Outer Dowsing Offshore Wind

Schedule of Changes for Plans

Deadline 4a

Date: February 2025

Sheet 32

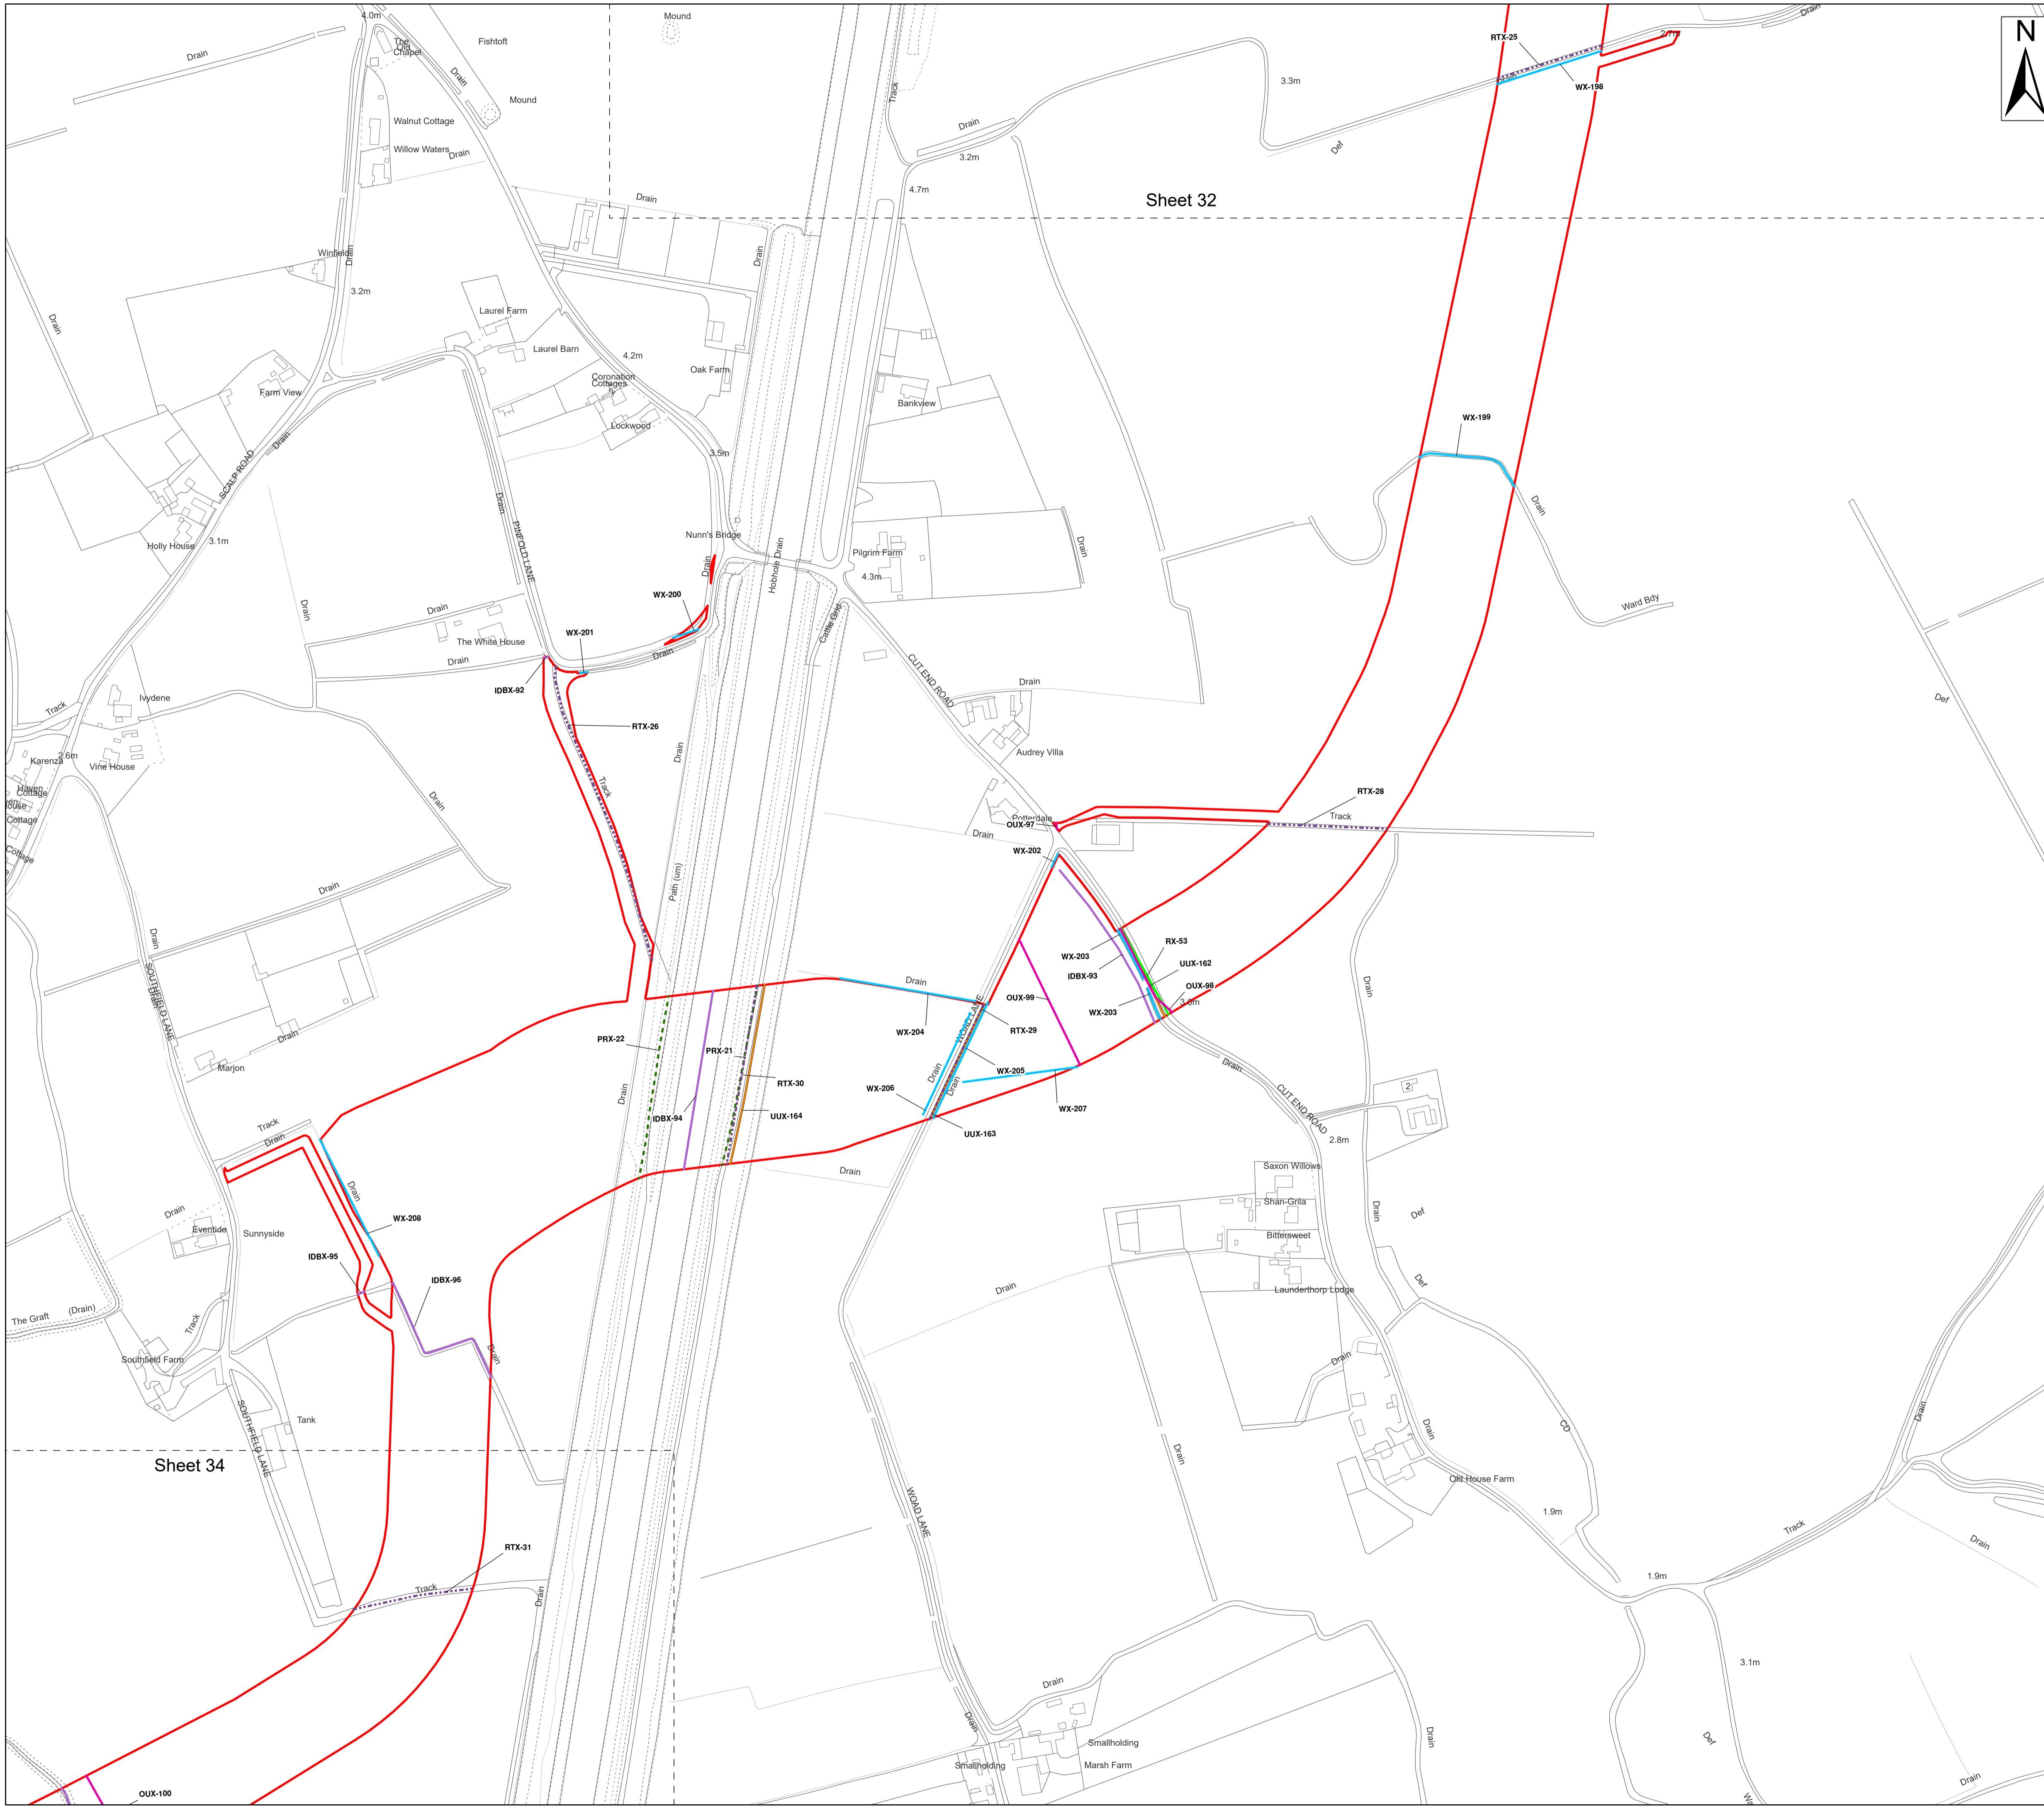
15. The Onshore Crossing Plan (2.18) and Public Rights of Way Plan (2.10) have been updated to show proposed new public rights of way (PRoWs) identified through consultation with Lincolnshire County Council (identified by their Boston Borough Council planning application reference numbers), along with the indicative routes for diversions. These proposed new PRoWs have also been included in the associated Crossing Schedule (6.3.3.2). The proposed new PRoWs and associated diversions (as appropriate) are shown on the following sheets of the Onshore Crossing Plan by reference to the crossing (PRX) or diversion reference (PRDX) and on the Public Rights of Way Plan by reference to the planning application reference number:

Plan number	sheet	Crossing Reference (Plan 2.18)	Plan	PROW Plan Reference (Plan 2.10)
31		PRX-20a		OMC B/24/0191 between points OMC36 and OMC 37
32		PRDX-4		Diversion between points CTD9 and CTD10
32		PRX-20b		CTD B/24/0197 between points CTD9 and CTD10
32		PRDX-5		Diversion between points CTD11 to CTD12
32		PRX-20c		CTD B/24/0197 between points CTD11 and CTD12 and OMC B/24/0197 between points OMC38 and OMC39
33		PRX-20d		OMC B/24/0198 between points OMC40 and OMC41
33		PRX-20e		CTD B/24/0198 between points CTD13 and CTD14 and OMC B/24/0198 between points OMC42 and OMC43
33		PRDX-6		Diversion between points CTD13 and CTD14
